**PARK HYATT SYDNEY**

**ACCESS REVIEW**

**Morris-Goding Accessibility Consulting**

30<sup>th</sup> June 2010

Key Plan Ground Floor

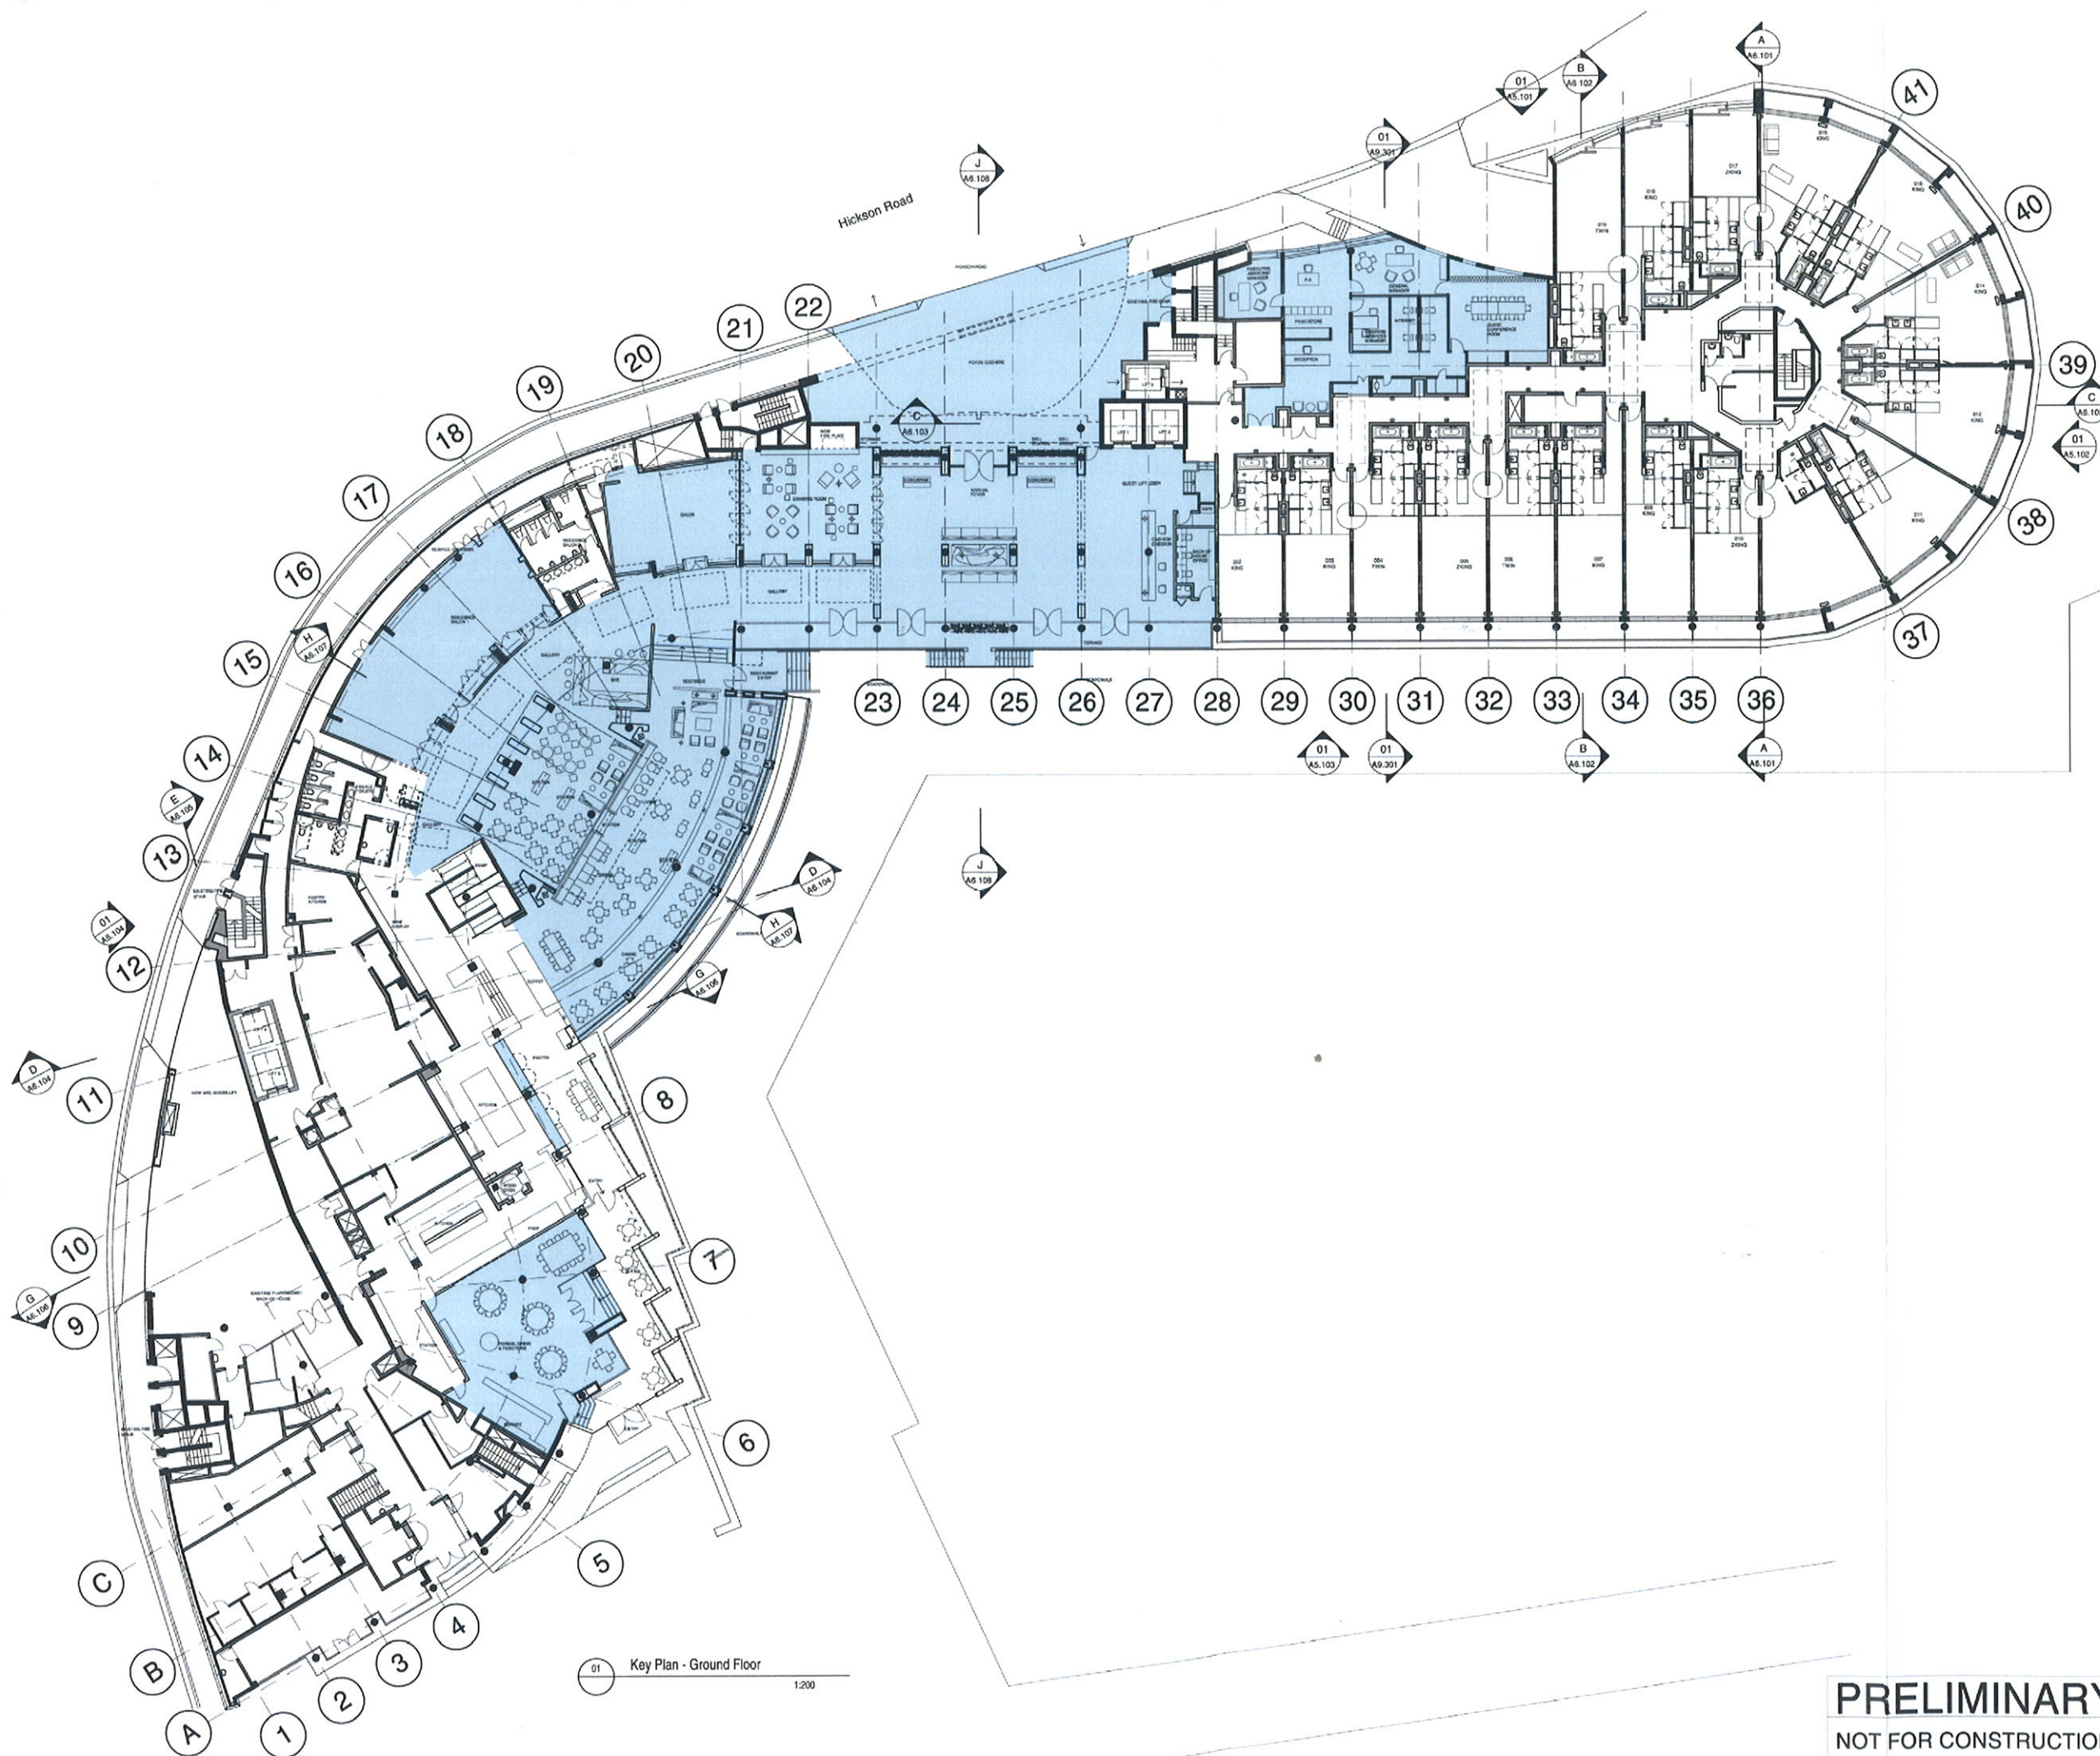
The accessible toilet has a dimension of 2000mm (W) x 2500mm (L) with a splayed wall, which is non-compliant under the City of Sydney Council Access DCP & AS1428.1. The accessible toilet entry door has a clear width of 850mm (870mm door leaf), compliant with AS1428.2.

- (i) Ensure the accessible toilet is enlarged to have a minimum 2800mm (L) x 1900mm (W) rectangle internal dimension. This will allow for an unobstructed circulation area of 2300mm x 1900mm around the toilet pan, with the basin to sit outside this area (basin encroach 100mm – max). This will cater for person (s) with larger wheelchairs (scooters), compliant with AS1428.2 & the City of Sydney Council Access DCP Clause 4.2.8. Currently the nominated accessible WC (at gridline 19) is inappropriate due to the angled wall.
